Application No: LU/240/21/PL
Site Address: 12 Cornwall Road Littlehampton BN17 6EE
Description of works: Change of Use from (C3) Dwelling house to 7 No. bed House in Multiple Occupation (Sui Generis)

Thank you for your internet representation made on 17th September 2021 which has been recorded as an objection with the comments as follows:

Drawing Title
Proposed Ground and First Floor Plans

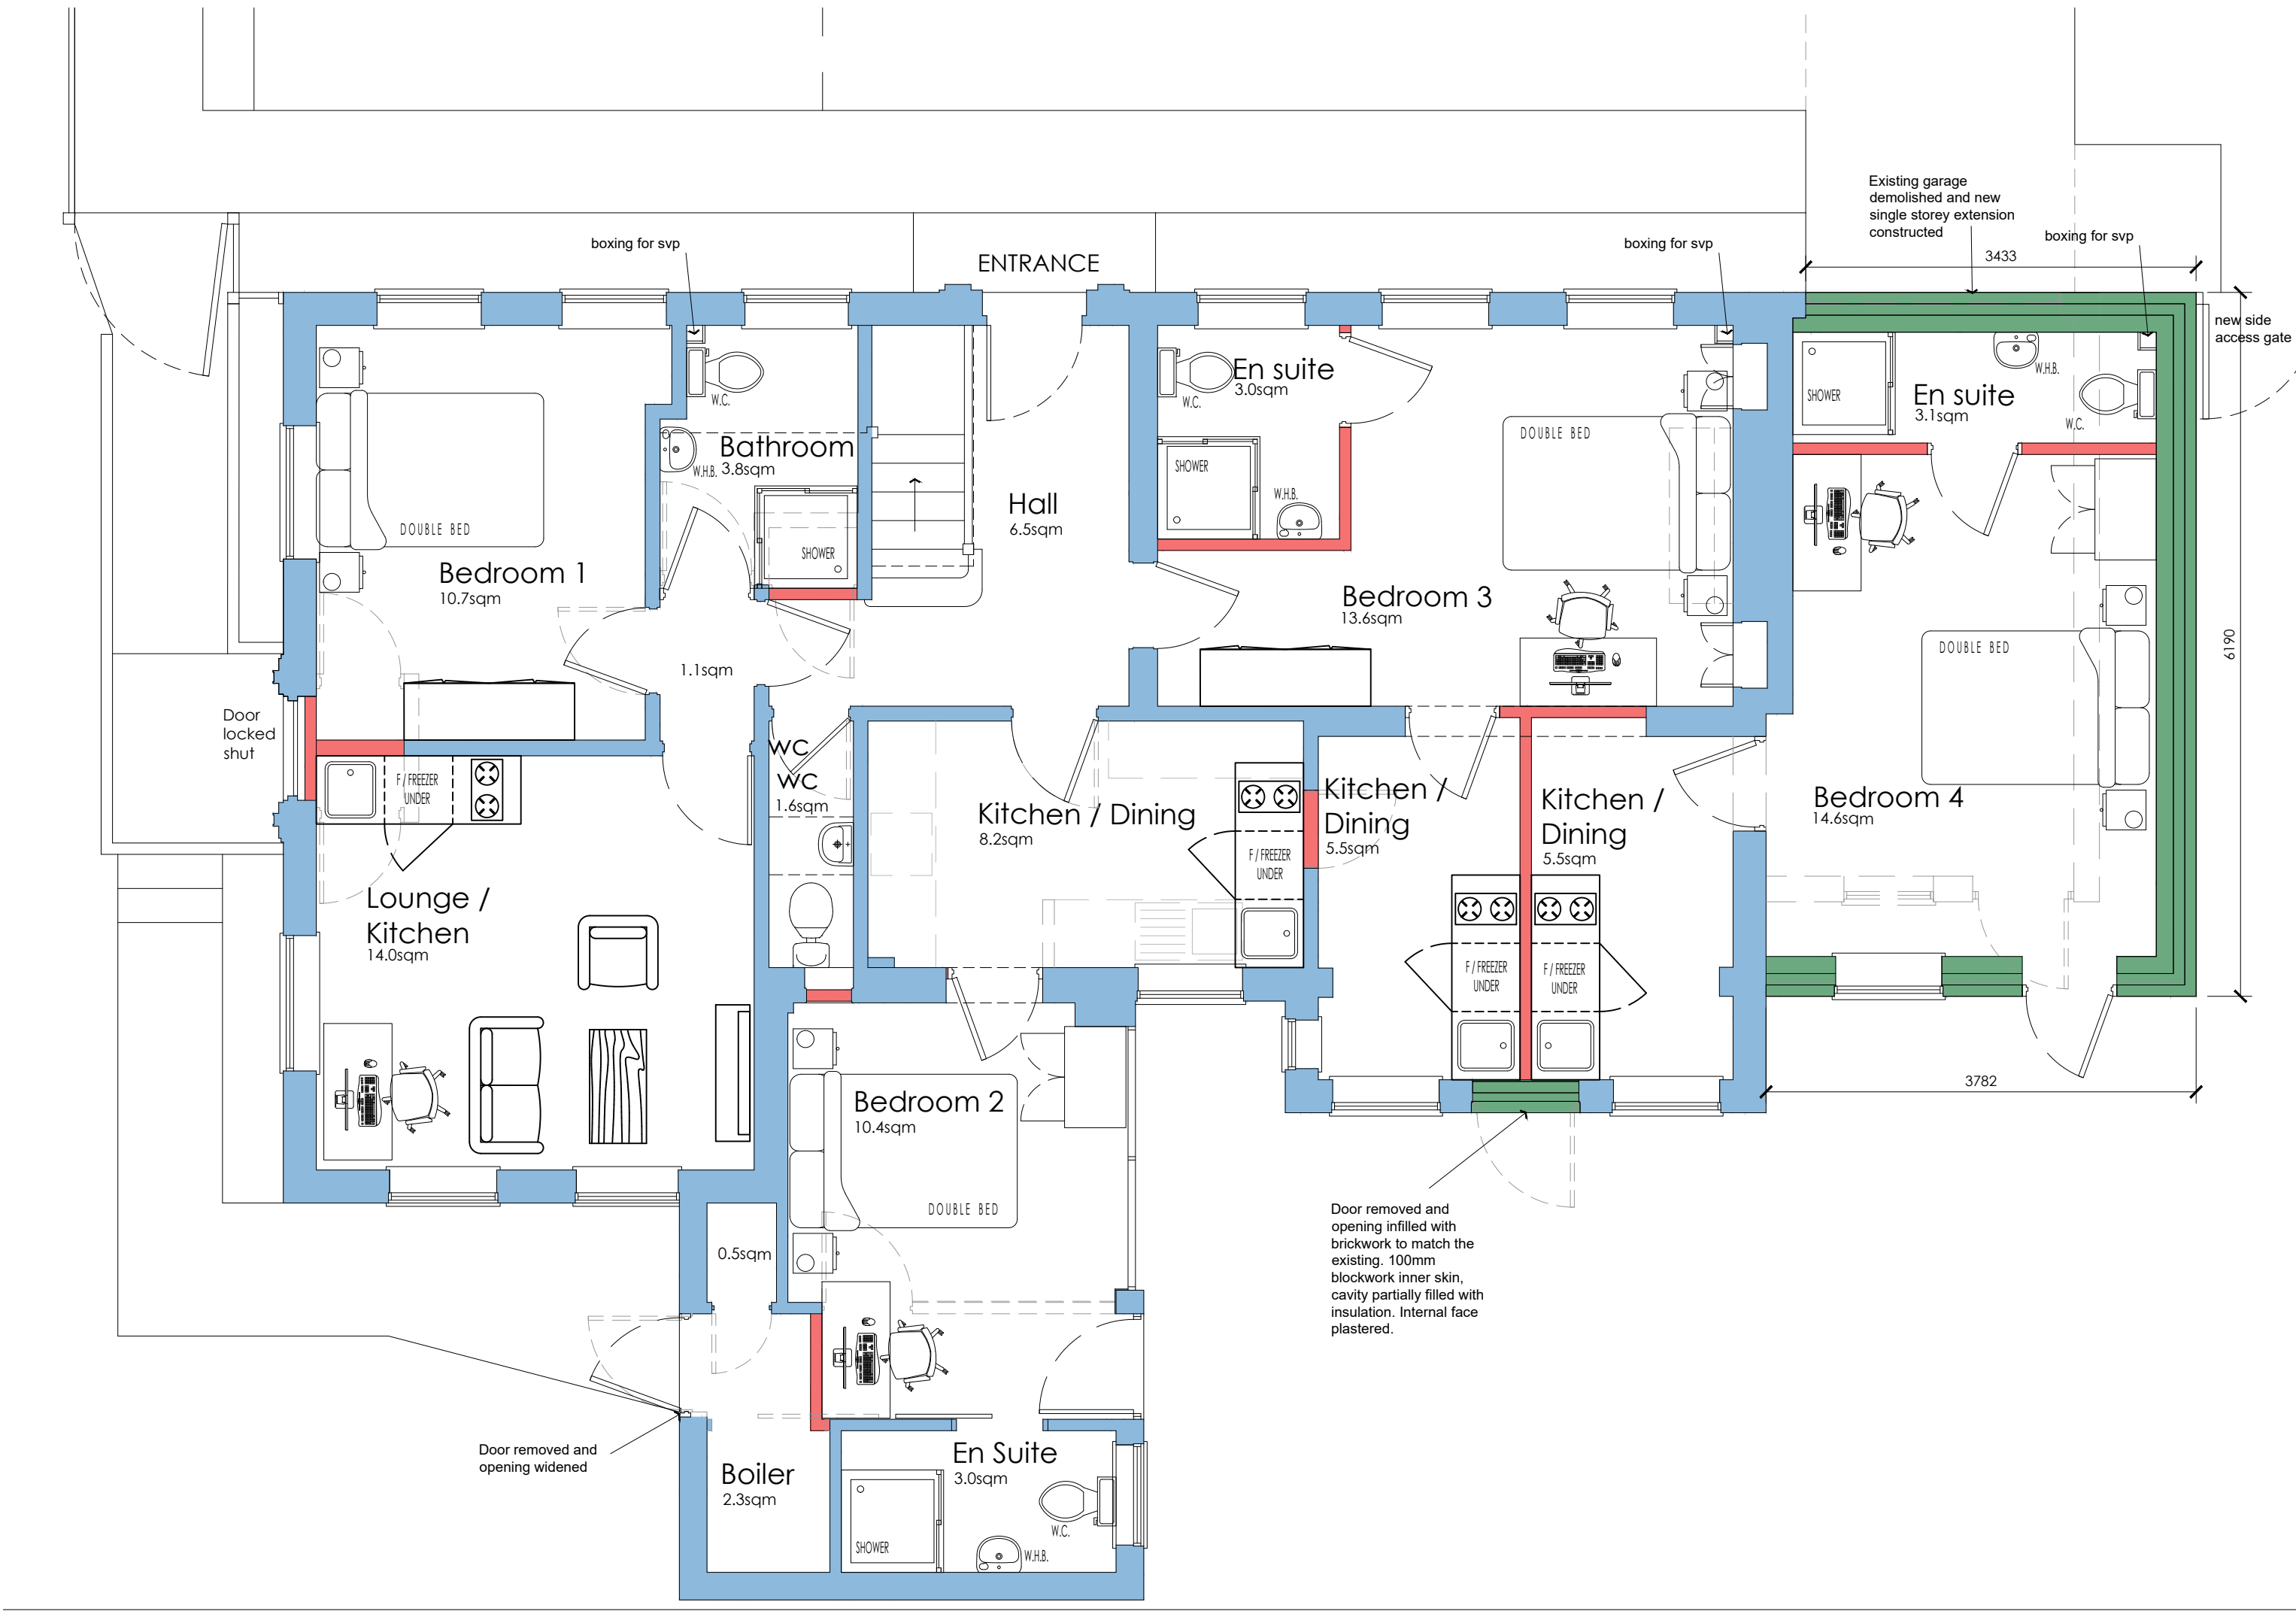
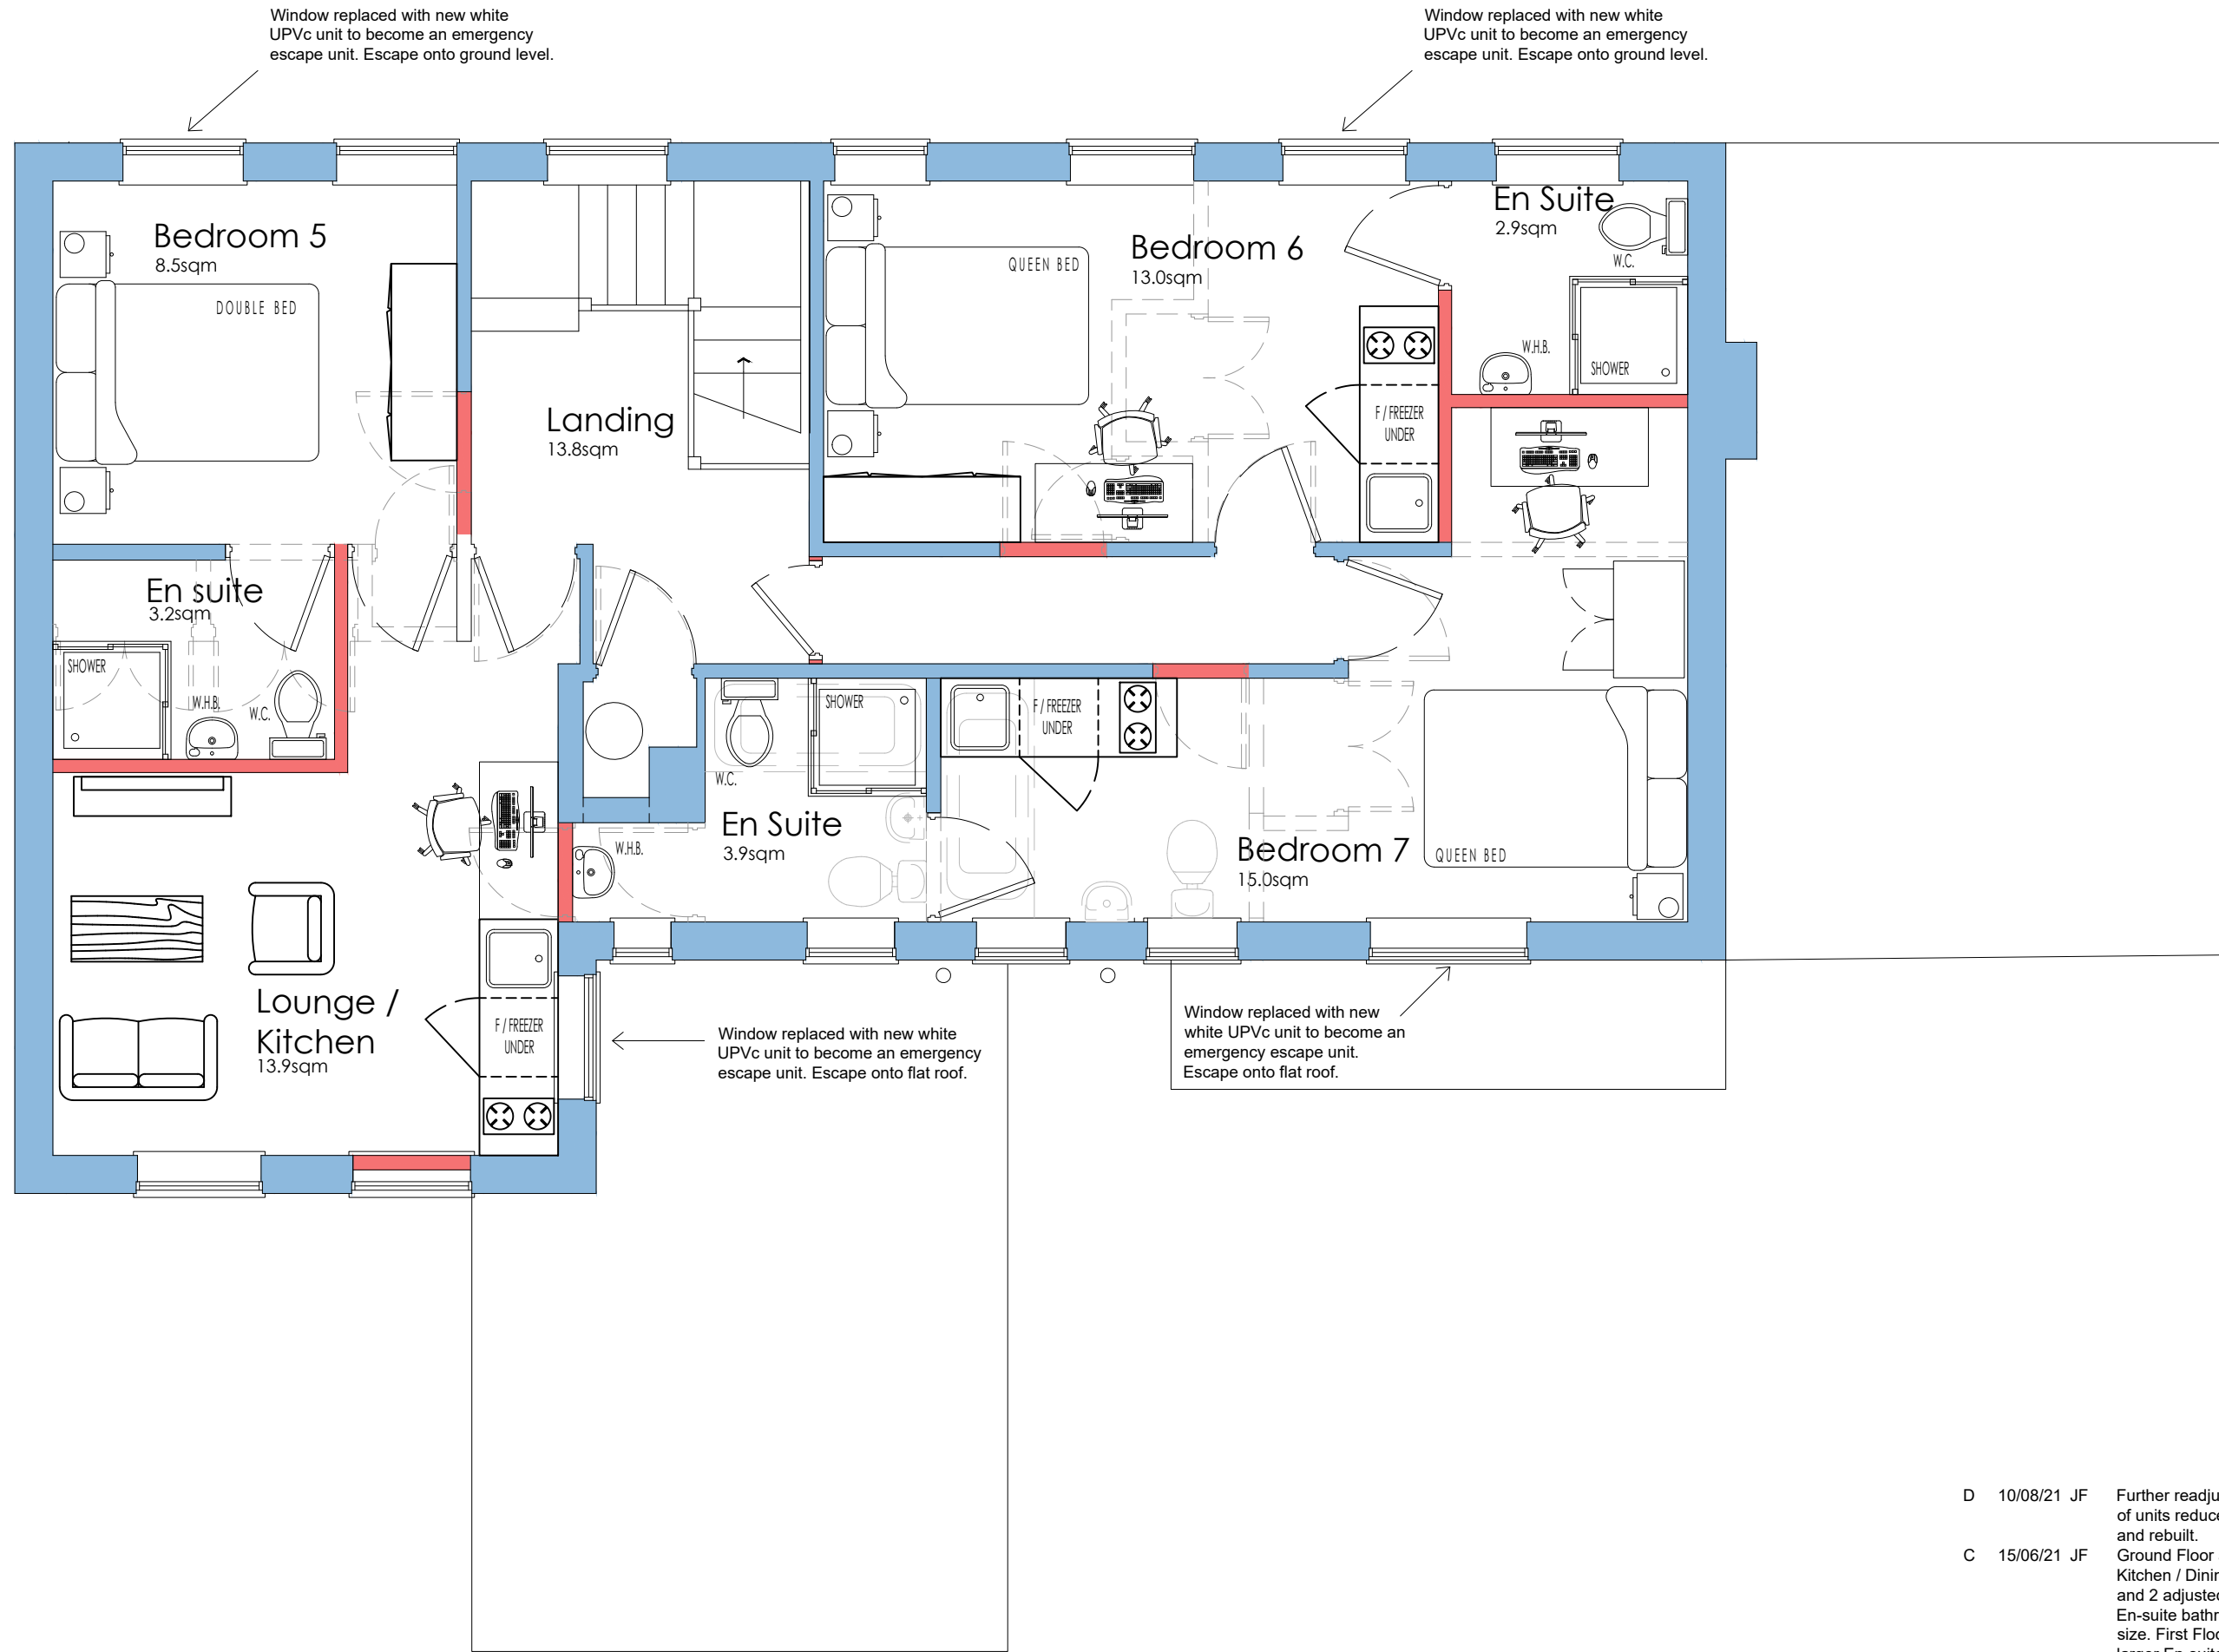
These proposals were considered by the Town Council's Planning and Transportation Committee at the meeting on Monday 13th September 2021. The Town Council objects to this application on the grounds that the application fails to incorporate appropriate levels of parking in line with West Sussex County Council guidance (3-4 required, 2 provided), contrary to Policy T SP1 (d) of the Arun District Local Plan, which means the application also fails to take into consideration the impact of development upon on-street parking, which is already heavily utilised in almost all the streets surrounding the application site. The proposal would therefore also have a negative impact on the amenity of the local area. Policy H SP4 of the Arun District Local Plan also includes a criterion that HMOs will only be approved if they "b. do not contribute to the generation of excessive parking demands or traffic in an area", which is also not met, particularly given the application site's placement on main thoroughfares to many local schools. Furthermore, the proposal appears to show that the development shall include no communal dining facilities, whereby the Arun District Council Standards for Housing in Multiple Occupation would require double bedrooms to be a minimum of 15m². The development therefore fails to meet these requirements for Bedrooms 1 (10.7m²), 2 (10.4m²), 3 (13.6m²), 4 (14.6m²), 5 (8.5m²) and 6 (13m²).
